CITY OF ALBUQUERQUE
MUNICIPAL DEVELOPMENT DEPARTMENT
ENGINEERING DIVISION/DESIGN HYDROLOGY SECTION

REF: DRAINAGE PLAN FOR PAGE APPLIANCE (H17-D34) RECEIVED OCTOBER 17, 1985

REF: DRAINAGE PLAN FOR PAGE APPLIANCE (H17-D34) RECEIVED OCTOBER
17, 1985

RE: REVISED DRAINAGE PLAN FOR PAGE APPLIANCE
RECEIVED OCTOBER 25, 1985 (H-17/D34)

LOTS B-1 & B-2, MIRAMONTES SUBDIVISION NO. 2
ALBUQUERQUE, BERNALILLO COUNTY, NEW MEXICO

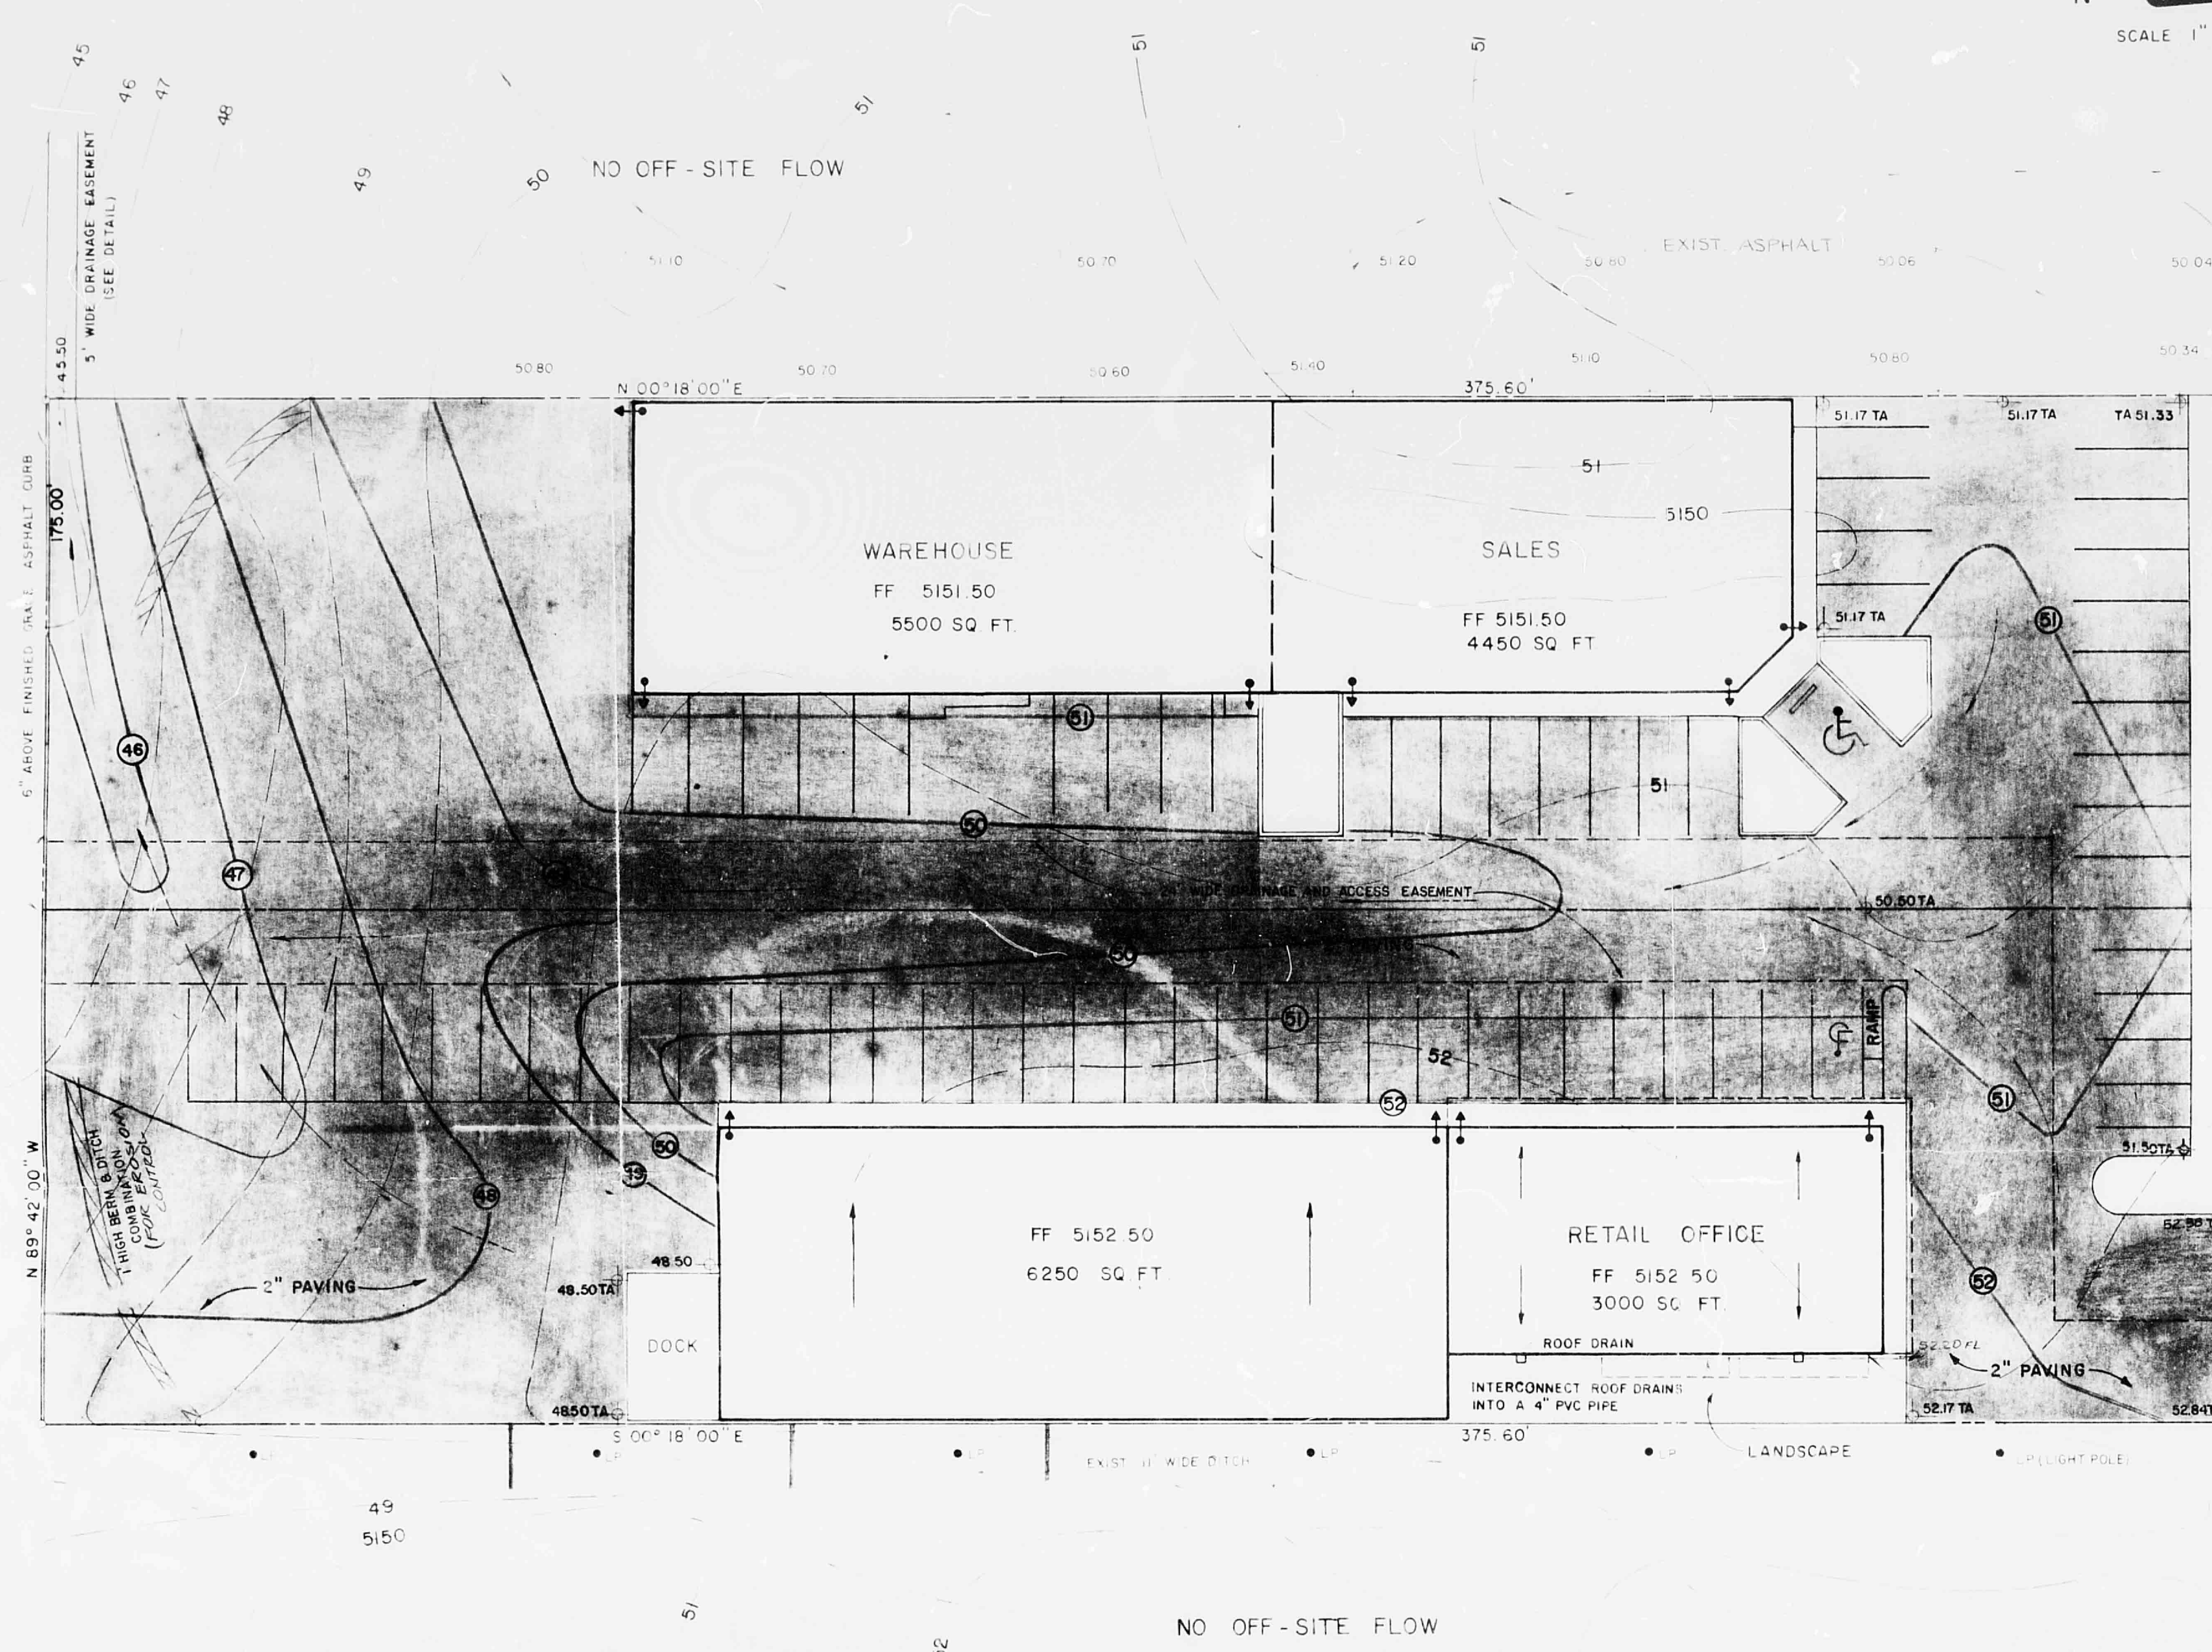
1. Erosion Control statement must also include erosion within the proposed site.
2. What is the purpose of the berm/ditch combination.

1. ✓ New information sheet with resubmittal designation.
2. ✓ Engineer's stamp with signature and revision date.
3. ✓ Replat of Lots A-2-1, B-1, and B-2 does not indicate any provisions for flows across lot lines, nor does it indicate the road easement that you indicate on your reduced copy; please address.
4. ✓ The Easement and Road Maintenance Agreement makes no mention for drainage provisions. Also, when submitted we require an approved filed copy.
5. ✓ How do you propose to convey the roof runoff from the retail office towards the asphalt area.
6. ✓ Any roof drains that outlet into landscaped area, provisions will need to be made to exit onto the asphalt areas, no ponding is allowed adjacent to the buildings.
7. ✓ Please indicate where your drive pad will be located off of Menaul, NE.
